Lower Thames Crossing

5.4.1.4 ~~Final~~ Agreed Statement of Common Ground between (1) National Highways and (2) Kent Downs AONB Unit (Tracked changes version)

Planning Inspectorate Scheme Ref: TR010032
Application Document Ref: TR010032/APP/5.4.1.4

*Local Landscape Character Area boundaries of the Kent Downs AONB LCA, West Kent Downs, Sub-areas Cobham and Shorne*

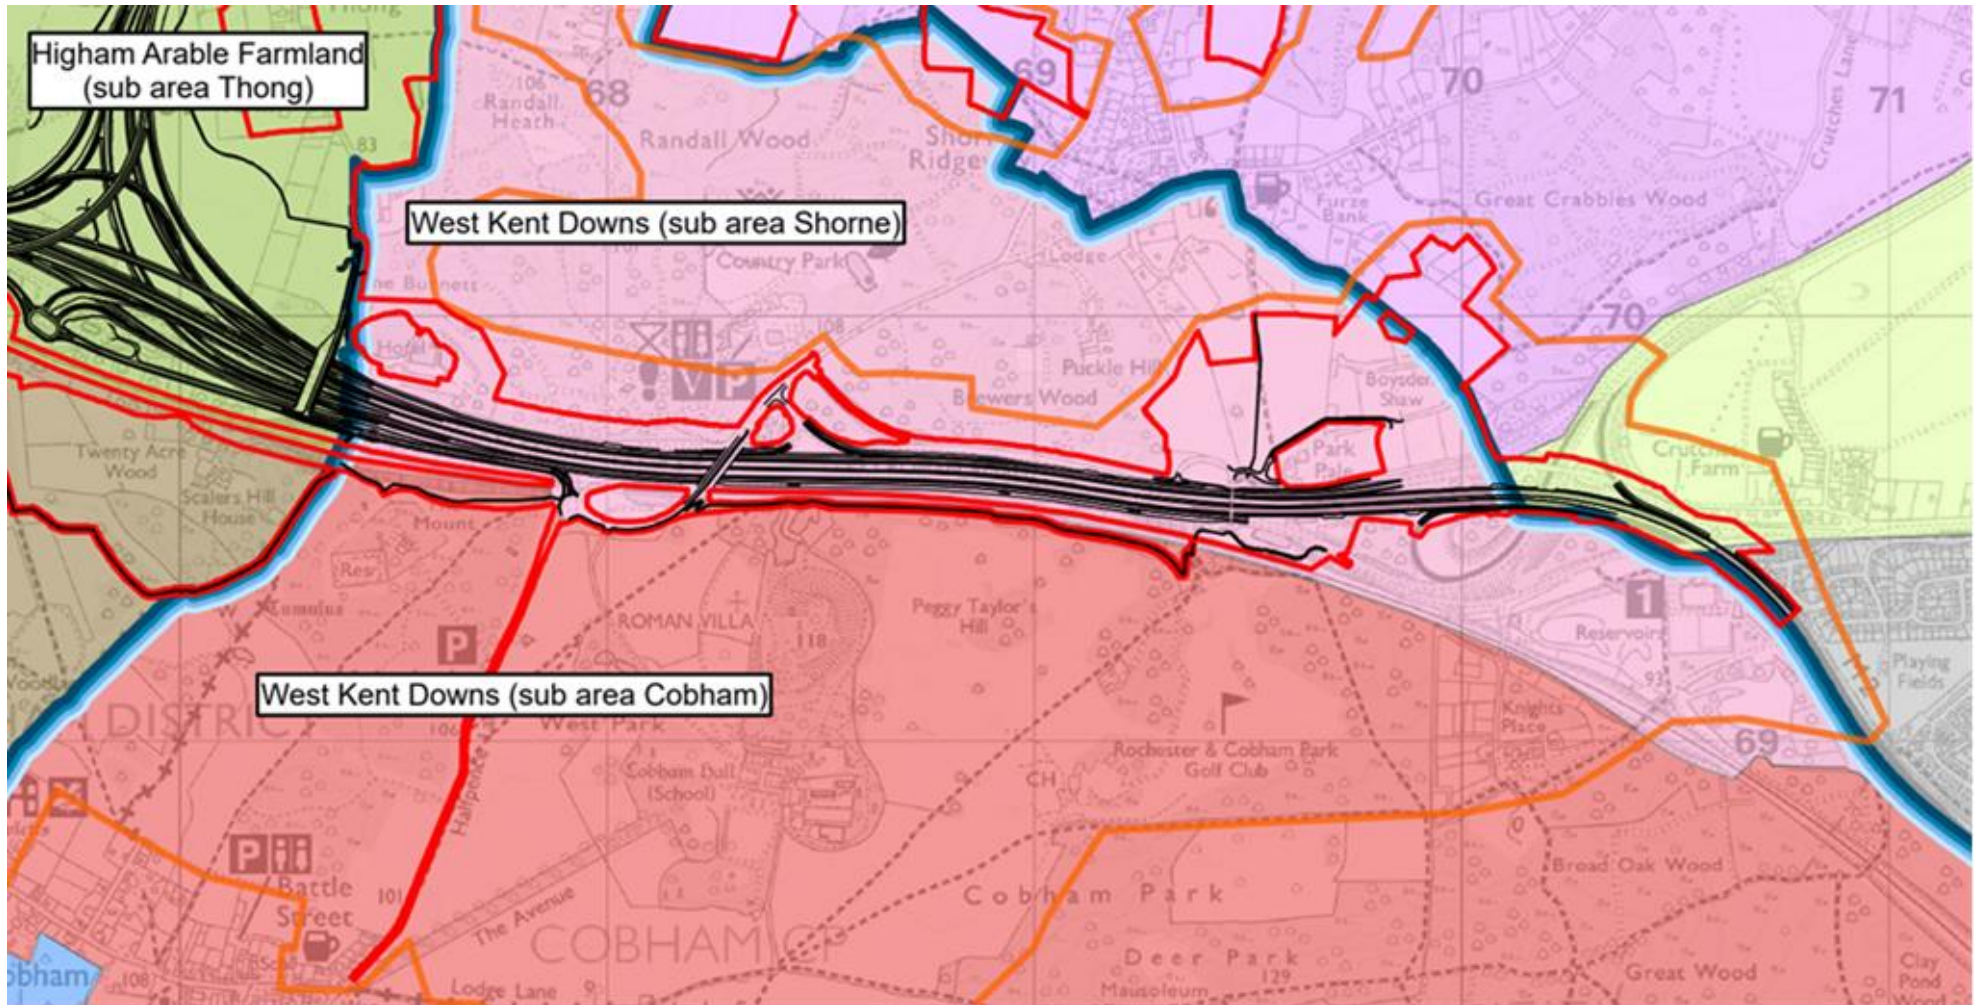
Landscape & Visual					
Baseline	2.1.42 WR (DL6)	The LVIA has assessed the impacts on the Kent Downs AONB Landscape Character Areas (LLCA) based on an adjusted plotting of the boundaries of the Shorne and Cobham Subareas of the West Kent	As detailed in Appendix A of Comments on Written Representations, the boundaries of character areas identified in the studies have been used to inform the definition of the LLCAs, which have	ES Chapter 7: Landscape and Visual Document Reference 6.1	Matter Not Agreed

Topic	Item No.	Kent Downs AONB Unit Comment	The Applicant's Response	Application Document Reference	Status
		<p>Downs Character Areas. This re-adjustment of the boundaries results in less of the proposed works falling within the Cobham sub-area as defined in the LVIA than within the Kent Downs published LCA and conversely, a greater proportion of the works falling within the Shorne sub-area.</p> <p><u>In respect of the revised assessment submitted at Deadline 8, notwithstanding the AONB Unit's continued contention that the impacts to landscape character at Design Year are generally underassessed, the AONB agrees with the Applicant's assessment set out in the revised landscape impact assessment tables using the non-adjusted boundaries, that the impacts of the Project would increase in respect of impacts in the Cobham Sub Area but would remain as reported for the Shorne Sub-area and overarching West Kent Downs LCA. The AONB Unit disagrees that there would be the assessed reduction at Construction in the Shorne Sub-Area from Major to Moderate.</u></p>	<p>been used as a basis for the assessment of effects on the landscape at the local level. In a limited number of locations, the boundaries of the published character areas have been slightly adjusted through detailed study and analysis undertaken for the LVIA in ES Chapter 7.</p> <p>From the Applicant's review of the West Kent Downs (sub area Cobham) LLCA and from its site visits, it is of the view that HS1 and the associated planting strongly define the northern extent of the Cobham sub area, and it therefore made sense for the Shorne sub area to incorporate the whole width of the A2 corridor, beyond HS1. Notwithstanding this slight difference in the West Kent Downs (sub area Cobham) LLCA boundary for the purposes of the assessment, the effects of the Project are fully assessed either as direct or indirect effects within the West Kent Downs (sub area Cobham) LLCA and/or the neighbouring West Kent Downs (sub area Shorne) LLCA. The findings of these two assessments are then brought together into a combined assessment for the overarching West</p>	<p>ES Chapter 7 (2) ES Addendum [Document Reference 9.8 (9)] Comments on WRs Appendix A: Statutory Environmental Bodies [REP2-046] Post-event submissions, including written submission of oral comments, for ISH11 [Document Reference 9.187]</p>

Topic	Item No.	Kent Downs AONB Unit Comment	The Applicant's Response	Application Document Reference	Status
		<u>The AONB Unit is of the view that as using the adjusted boundaries results in a reduced assessment of the effects for the Cobham Sub-Area, the assessment should be based on the published LCA boundaries.</u>	Kent Downs Landscape Character Area (LCA) 1A. The combined effects reported in the landscape impact summary in Tables 7.33 and 7.34 in Section 7.9 of ES Chapter 7: Landscape and Visual and the overall conclusion of the landscape and visual impact assessment would therefore not differ if the Cobham and Shorne sub area boundary is drawn in a different location. <u>The Applicant has published a without prejudice assessment using the published LLCA boundaries for Deadline 8.</u>		
Methodology	2.1.4	Viewpoints and photomontage locations and methodology have been agreed with the AONB Unit.	Methodology agreed.	<u>ES Chapter 7: Landscape and Visual [Document Reference 6.1 ES Chapter 7 (2)]</u> <u>ES Addendum [Document Reference 9.8 (9)]</u>	Matter Agreed
